Planning Application Ref: FP/203/17/PL

Location : 7 Middleton Road, Felpham

Description of works: Demolition of outbuildings & erection of 1 No dwelling to the rear [resubmission after FP/137/17/PL].

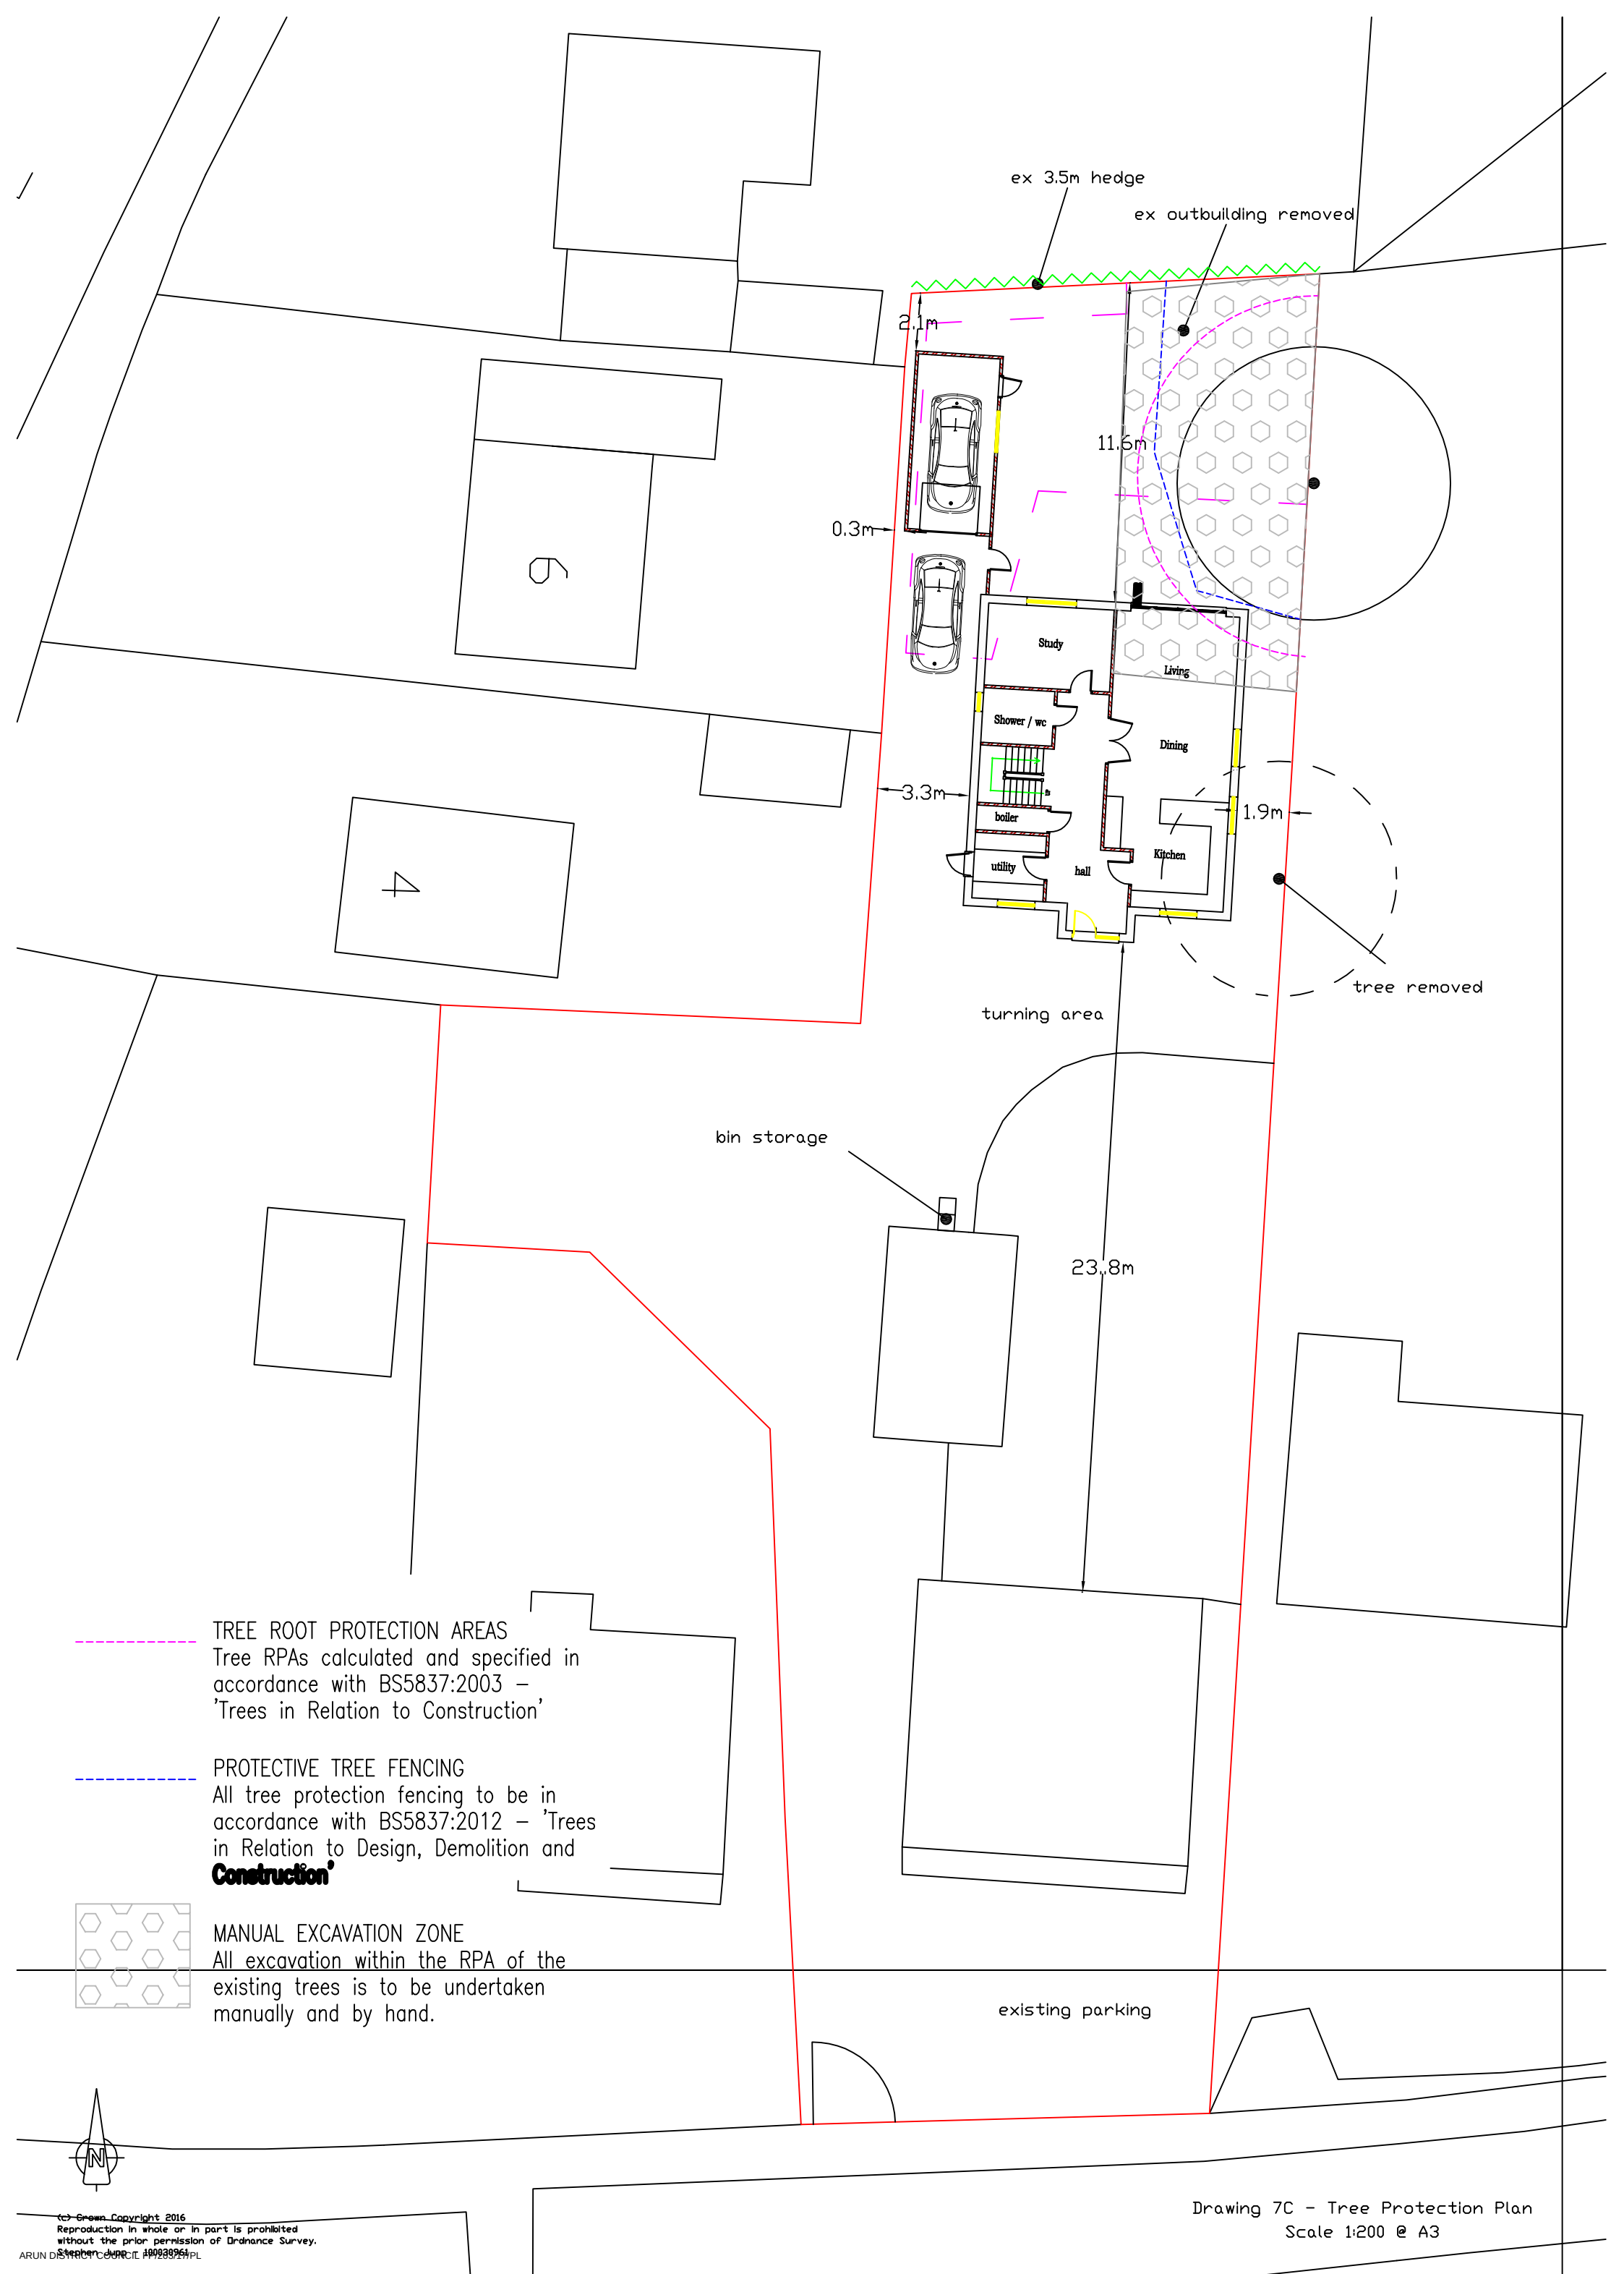
- The applicants Planning Consultants report has grasped the main gist of the issues in that phased demolition is advised and then erect protective fencing immediately that open ground is exposed beneath the existing structure.
- However, one key element is missing in that the protective fencing is shown to be hard up against the new building and in this position it would hinder the construction process.

- If they are not going to use the services of an Arb Expert on this then the Planning Consultant will need to look up BS5837:2012 section 6.2.3.3 and recommend at least 1.5m of ground protection around the corner of the new building footprint closest to the retained tree in order that scaffolding can be erected to facilitate the build – if scaffolding is not required then ground protection will still be needed to allow for pedestrian access to build the dwelling.
- Thus as things stand I would sustain my **OBJECTION** to the scheme.
